OUT15/11033

**Horsley Park Meter Station Upgrade Project (SSI_6681)
Response to exhibition of Environmental Impact Statement**

Horsley Park Meter Station Upgrade Project (SSI_6681) Response to exhibition of EIS Comments by NSW Office of Water

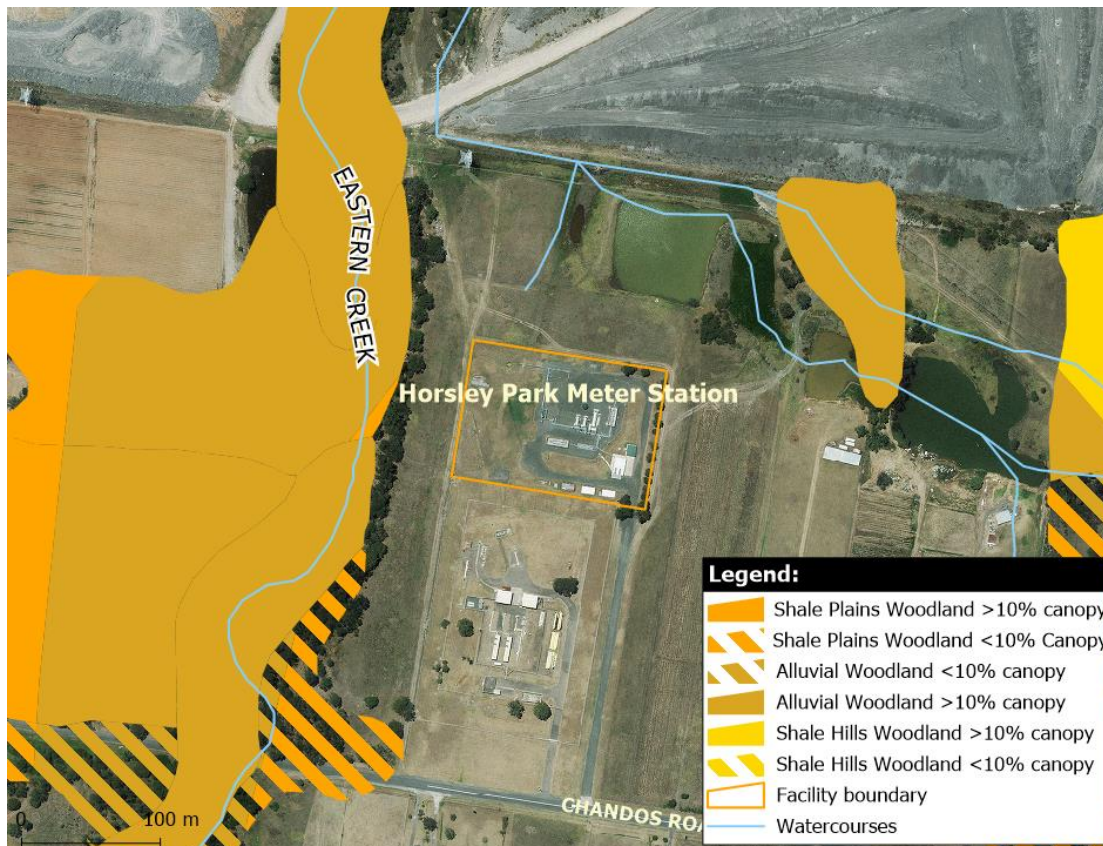
Figure 7.2 in the EIS shows there is currently a vegetated riparian corridor along Eastern Creek which includes remnant Alluvial Woodland and Shale Plains Woodland. The width of the corridor along the right bank of the creek near the site appears to be currently approximately 27-28 m wide. According to the Plan of Management, the site is located within Precinct 9 (Horsley Park) and Precinct 9 appears to show that the proposed bushland corridor will extend beyond the existing remnant vegetation (ie the corridor will be located closer to the Horsley Park meter station site boundary).

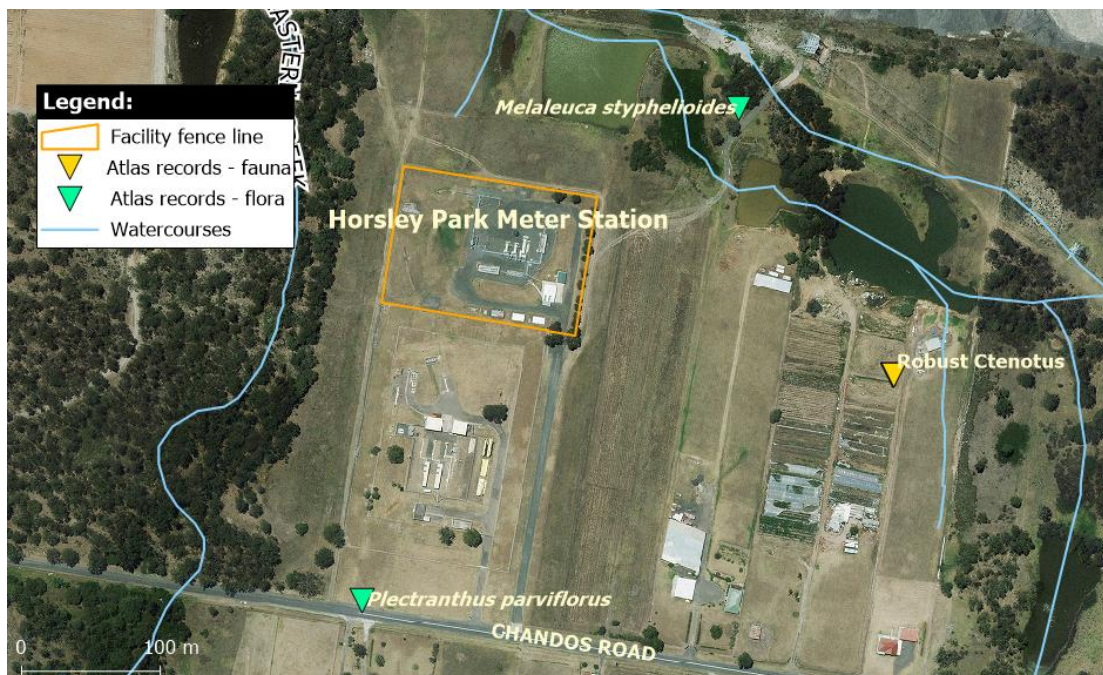
Appendix B of the EIS indicates Eastern Creek is located about 70m to the west of the existing facility boundary (Table 4.4, page 8). Based on Figure 7.3 in the EIS there currently appears to be about a 36m wide setback between remnant riparian vegetation and the site boundary. It is suggested the proponent provides details, including a scaled plan on:

- the footprint of the proposed bushland corridor as identified in the Plan of Management in relation to the site boundary
- the minimum setback distances between the site and the proposed bushland corridor
- asset protection zone requirements for the site and whether there is an issue in relation to APZ requirements and the future rehabilitation and revegetation of the corridor. If so, it is recommended mitigation measures are provided to address this.
